RE: REQUEST FOR ADDITIONAL INFORMATION – SSDA 7388 MOD 10

This submission has been prepared by Ethos Urban on behalf of Grocon (Darling Harbour) Developments (Grocon), in response to the Request for Additional Information (RFI) issued by the Department of Planning and Environment (DPE) on 25 November 2019, relating to SSDA 7388 MOD 10. SSDA 7388 MOD 10 seeks approval for a redesign of the SHFA building, modifications to the Porte Cochere (Ribbon building) form and material finish, modifications to the playground area and reconfiguration of bicycle parking, adjustment of public domain levels at the front of the building to provide stepped levels, and an adjustment of the approved signage zones.

Table 1 Response to DPIE RFI items

PUBLIC DOMAIN PLAN

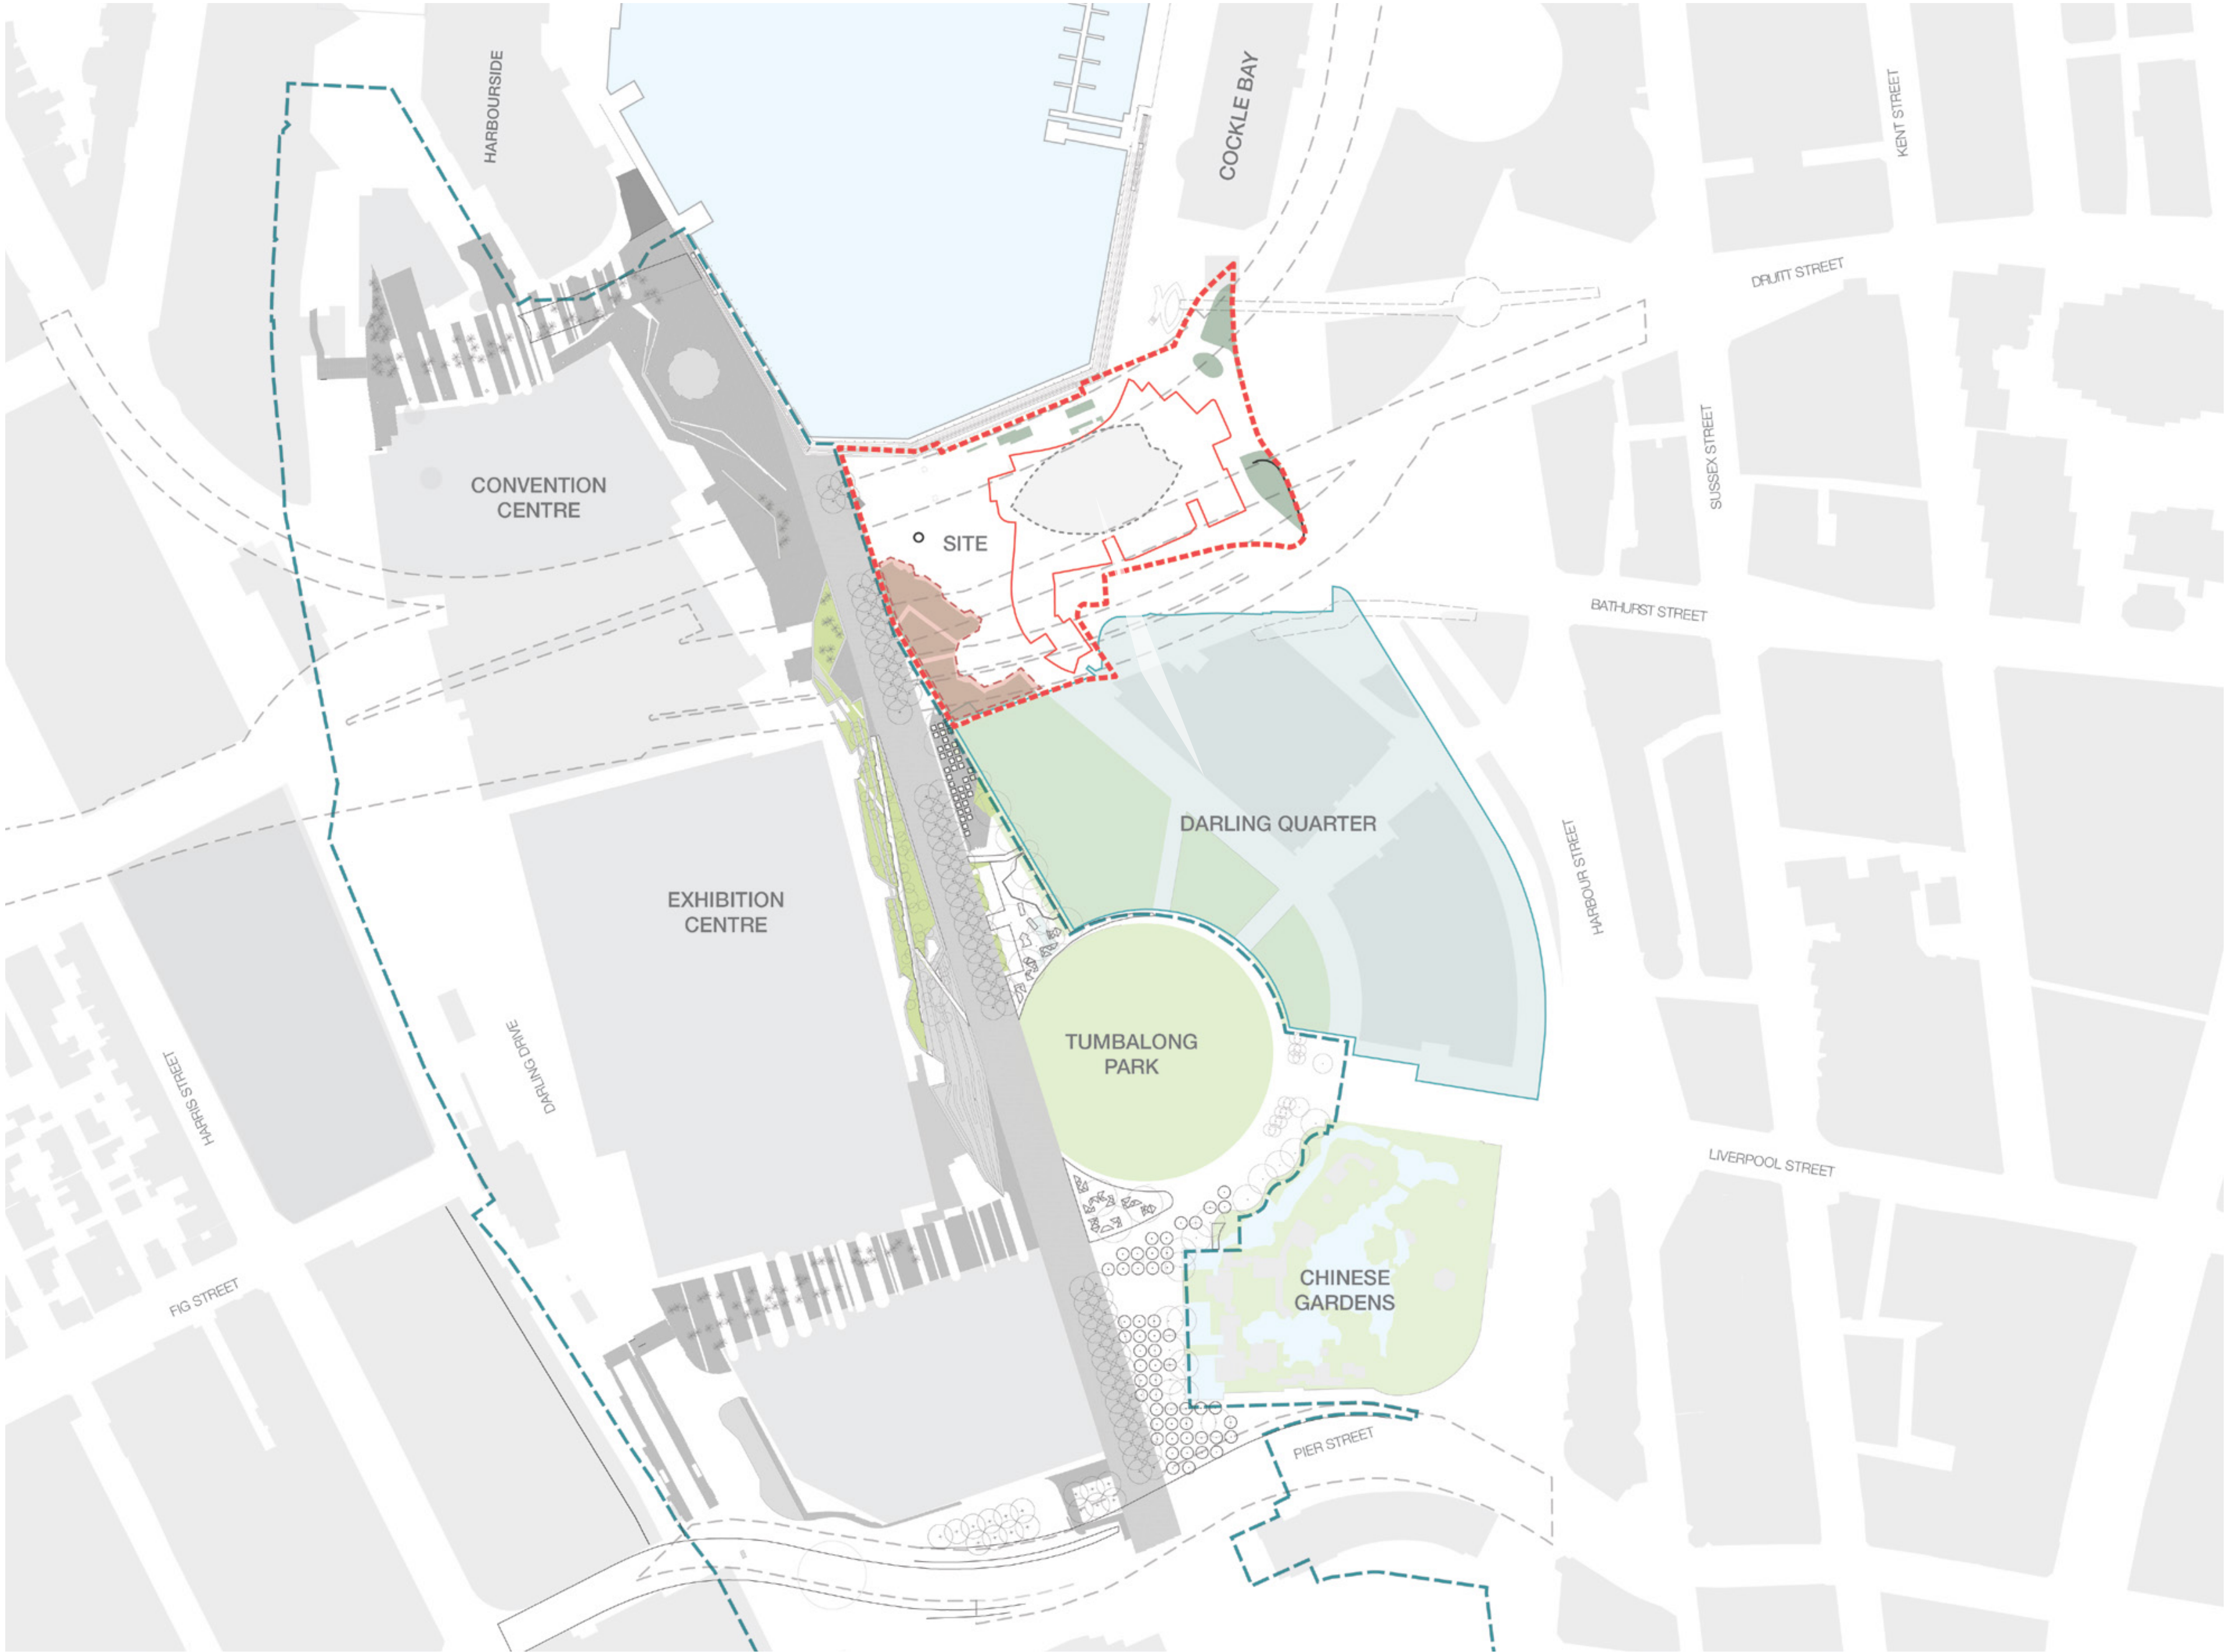
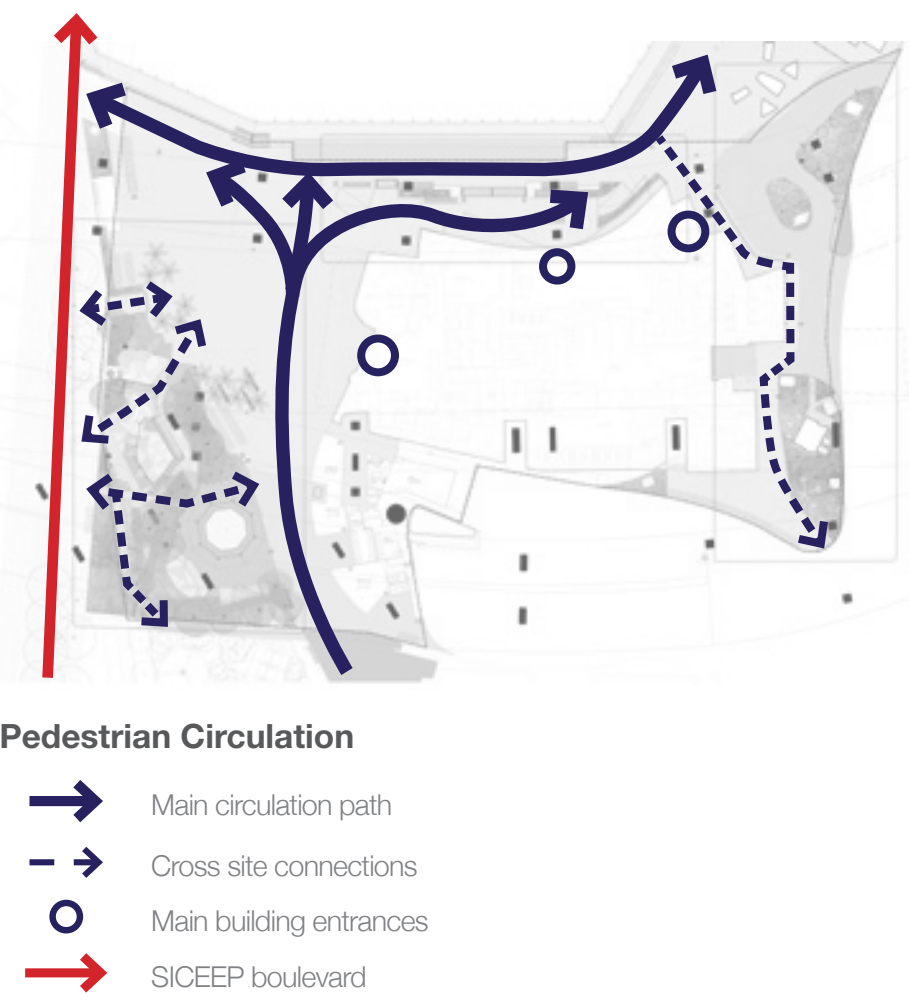
<i>A number of changes to the public domain, including the relocation of the Jay Flowers sculpture, have not been addressed in the Modification Report. Please provide public domain plans which clearly identify all proposed changes (highlighted/bubbled) and ensure all changes are addressed in the Modification Report.</i>	Revised Public Domain Plans have been prepared by Aspect Studios at Attachment B rectifying the issues raised. All of the proposed changes to the public domain were described in the original planning statement with the exception of the relocation of the Jay Flower. The proposed location has been the subject of discussions with SHFA and the proposed location has been approved.
<i>The proposed public domain plans include public art (the Kraken) which does not form part of the modification. Please remove all reference to this element from the submitted plans.</i>	Revised Public Domain Plans have been prepared by Aspect Studios at Attachment B with all references to the Kraken removed. Public art components of the proposed development are currently under consideration at the City of Sydney under D/2019/1231.

PUBLIC DOMAIN SECTIONS

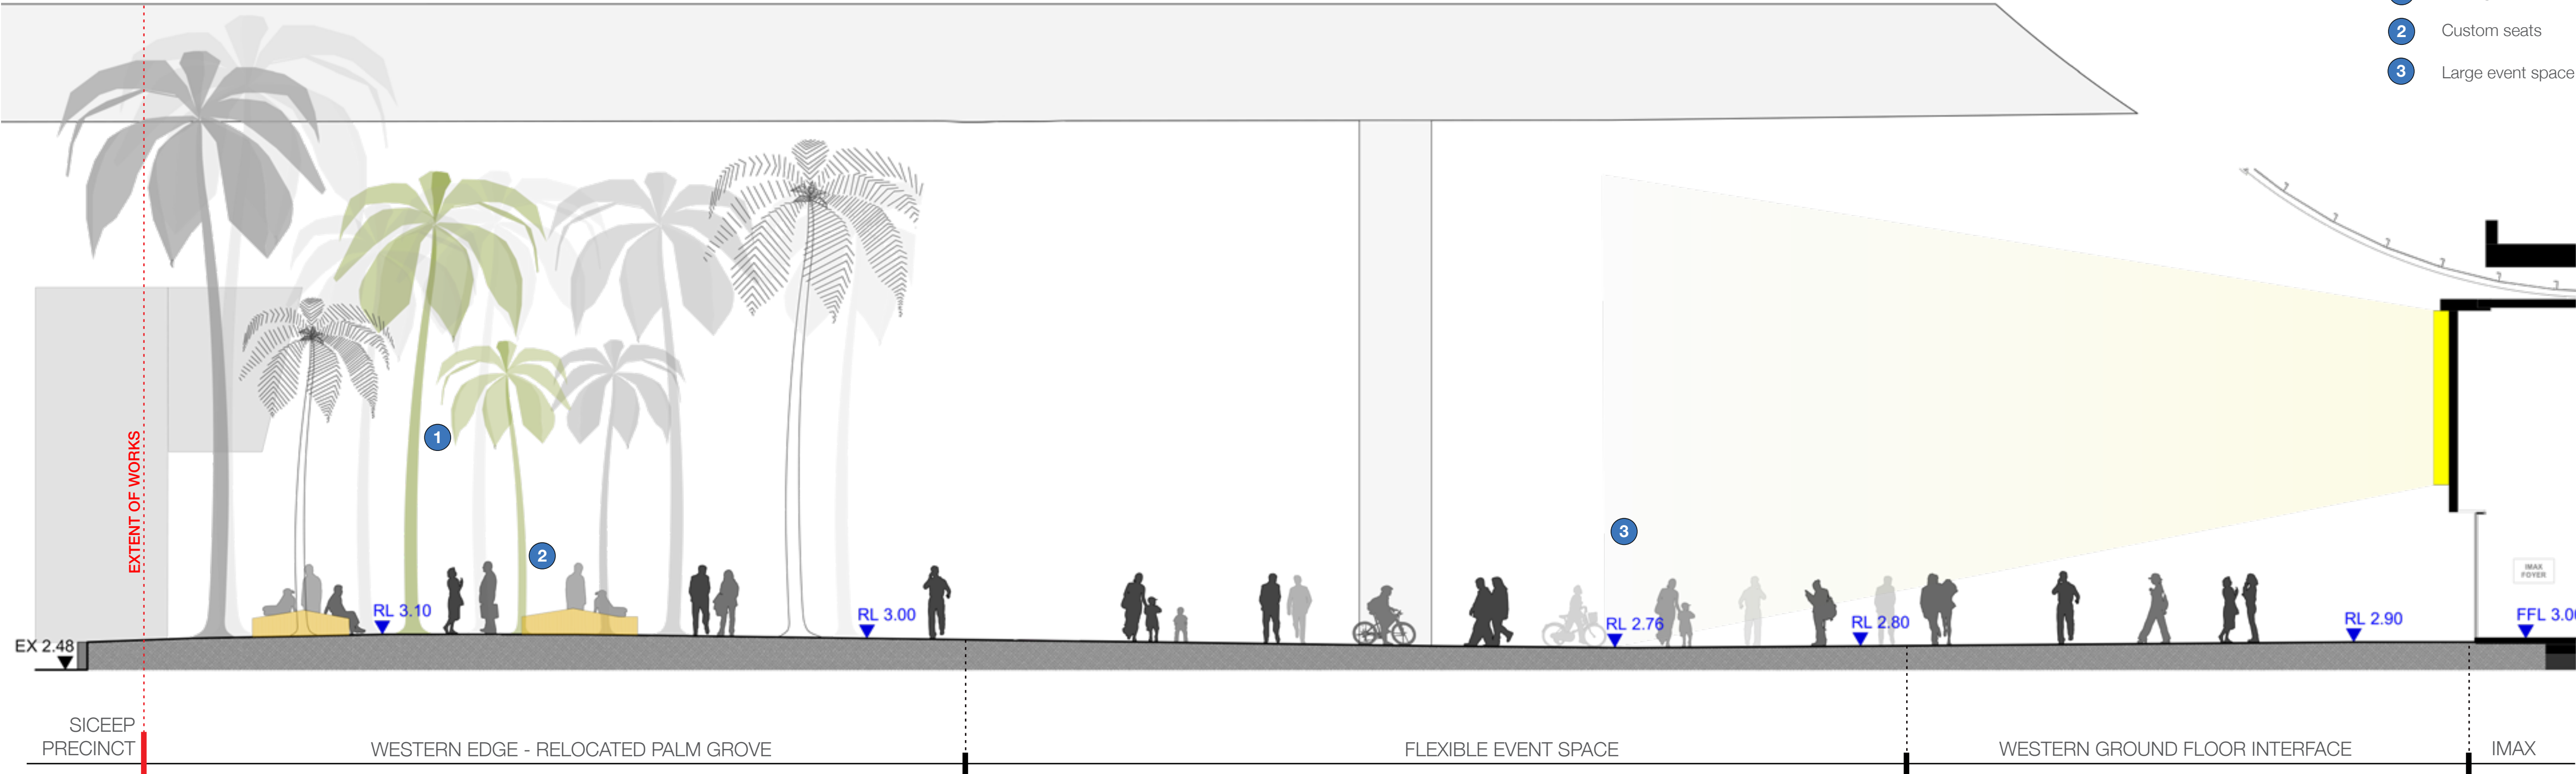
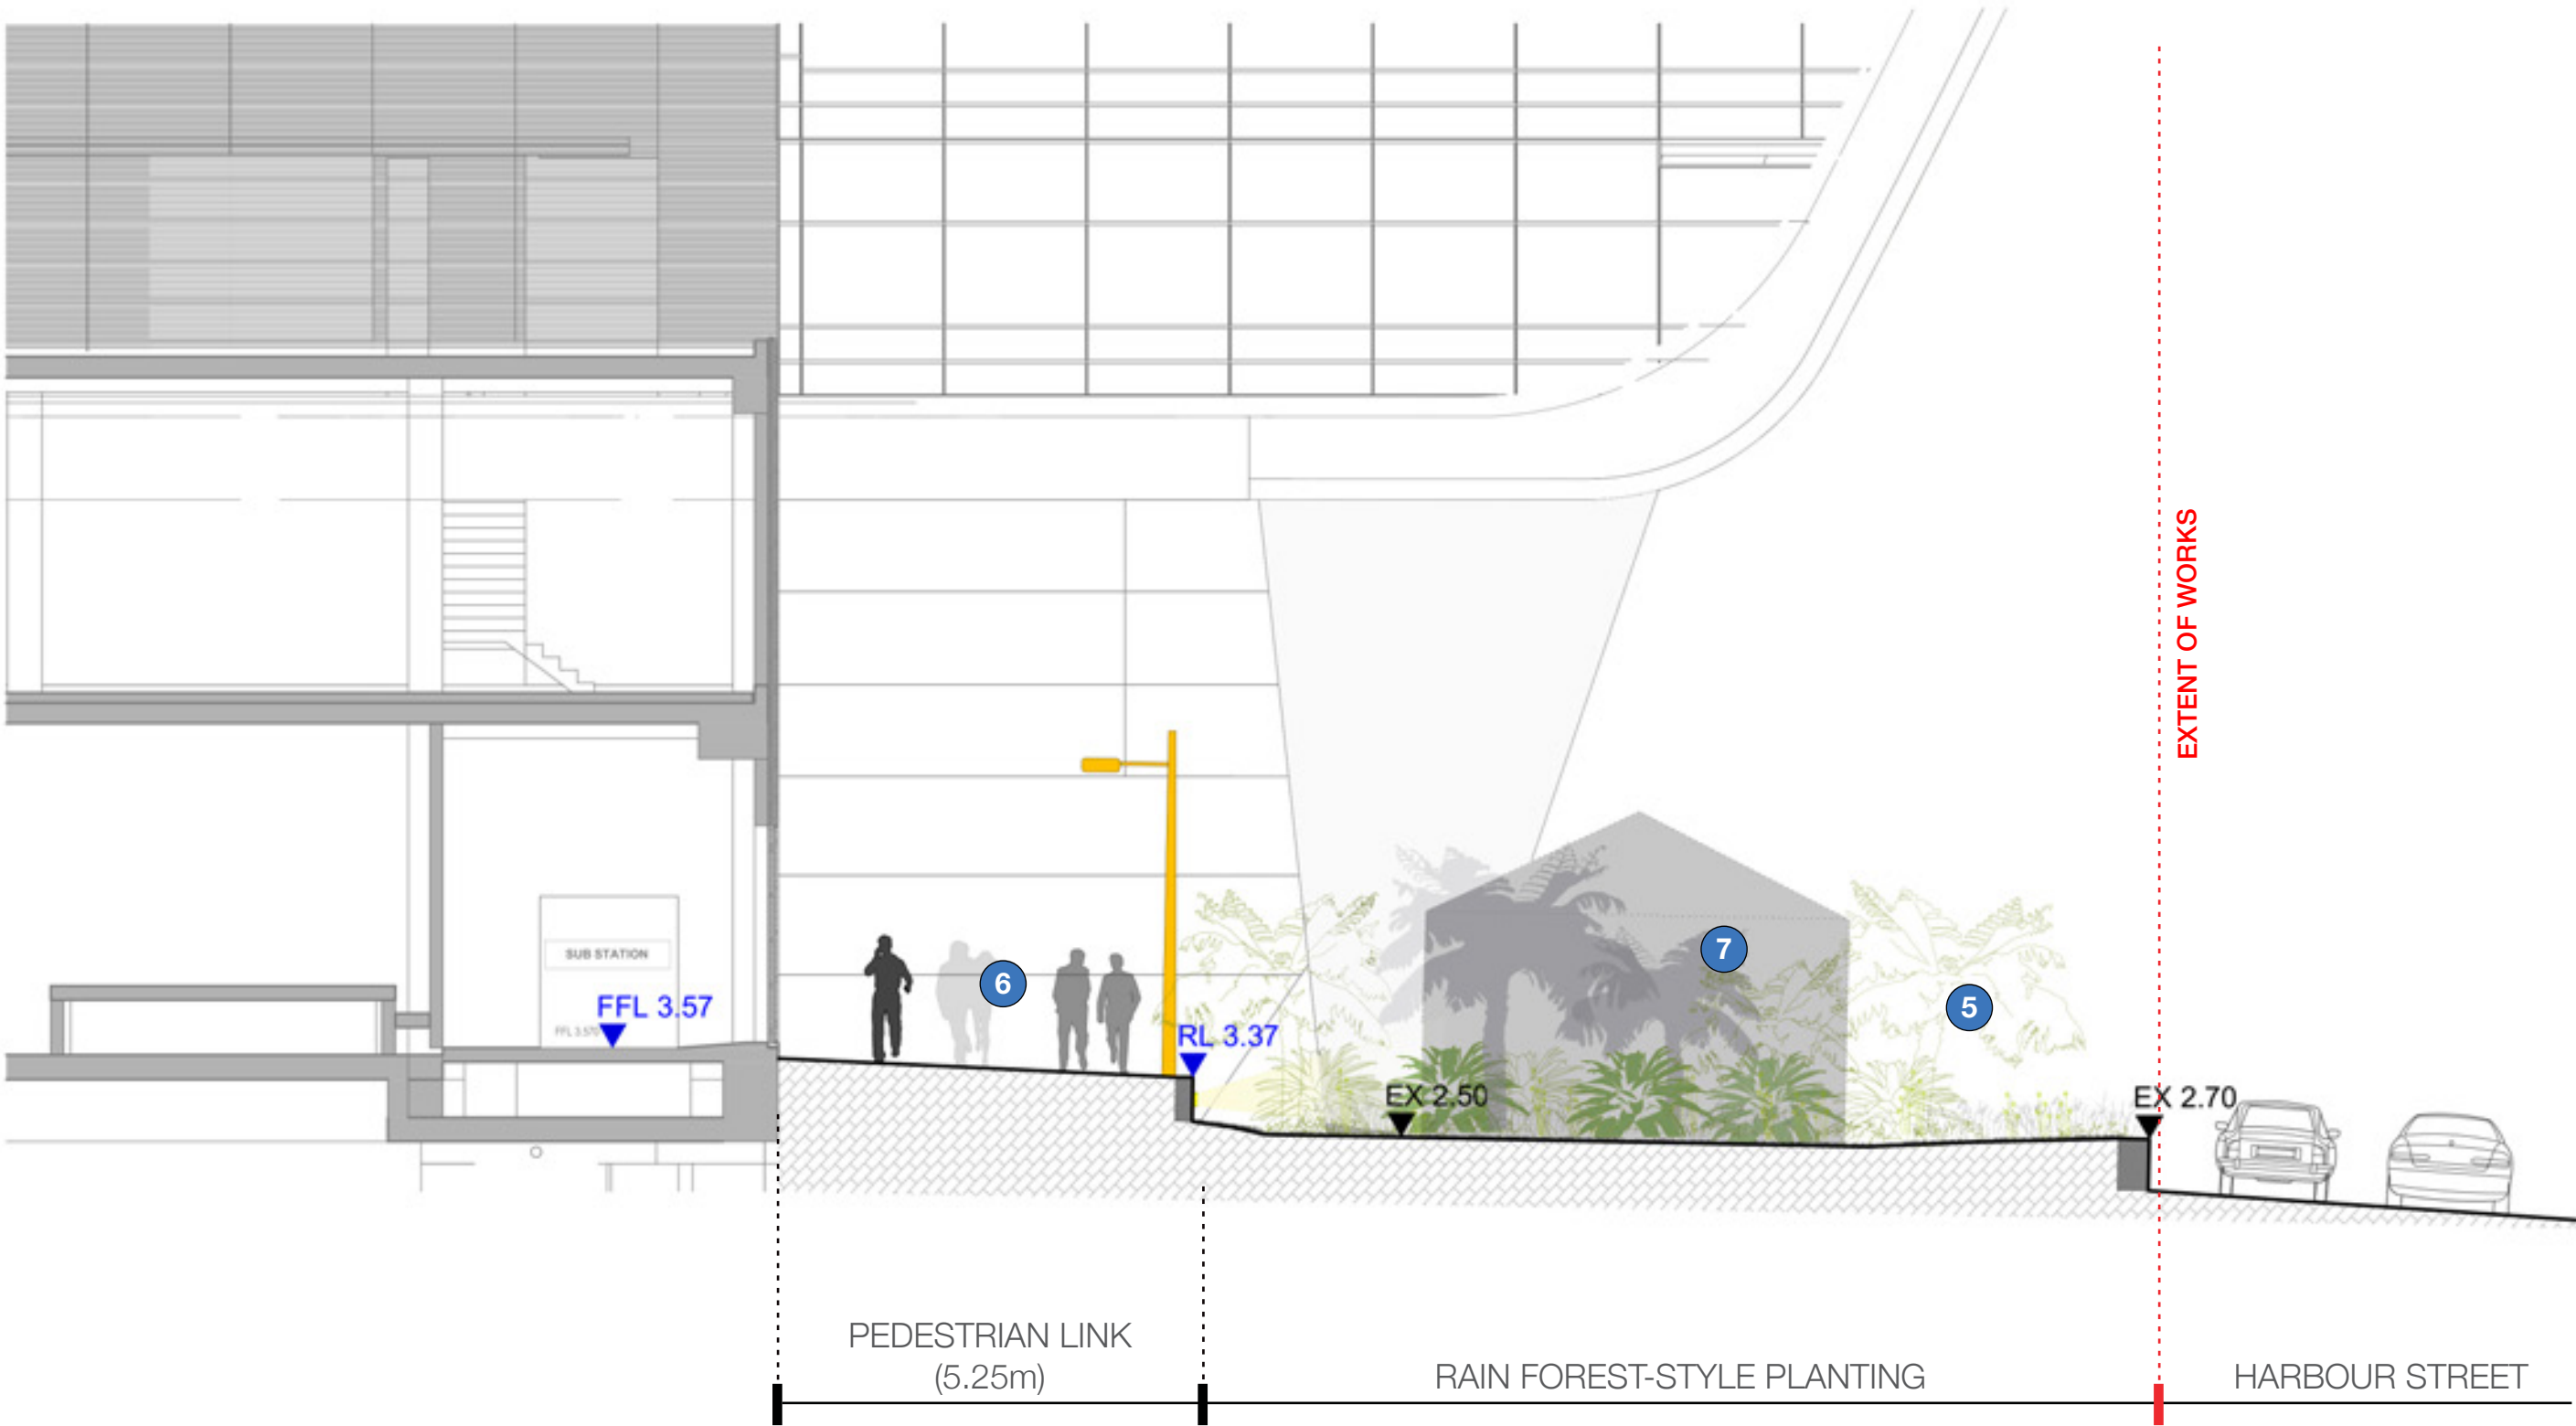
Public Domain	
<i>Grading of footway is unclear. The proposal notes that the existing approved design has a 1:50 – 1:100 cross fall from the site boundary to the north, to the building line of The Ribbon. Terraced footways should consider appropriate cross-falls and drainage to prevent localised ponding on footways.</i> <i>Further, consideration should be given to the cluttering of the public domain and the reduction of clear passageways in this busy area. The width of the upper footway between the north elevation of the Ribbon building to the proposed public domain elements of seating and landscaping has a pinch point adjacent to the proposed outdoor dining areas. The proposed outdoor areas for the Ribbon building is subject to a separate Development Application (D/2019/1231) delegated to the City that is currently under assessment. It proposes outdoor seating widths of approximately 2.3m from the Ribbon building. The City recommends at least a minimum 4m footway width travel path be maintained for a clear path of travel between the proposed public domain embellishments and future outdoor seating zones.</i>	Revised public domain plans have been prepared by Aspect Studios at Attachment B with footway gradings clearly shown. A minimum 4 metre width is to be maintained across the site; this is more clearly delineated under the revised plans.
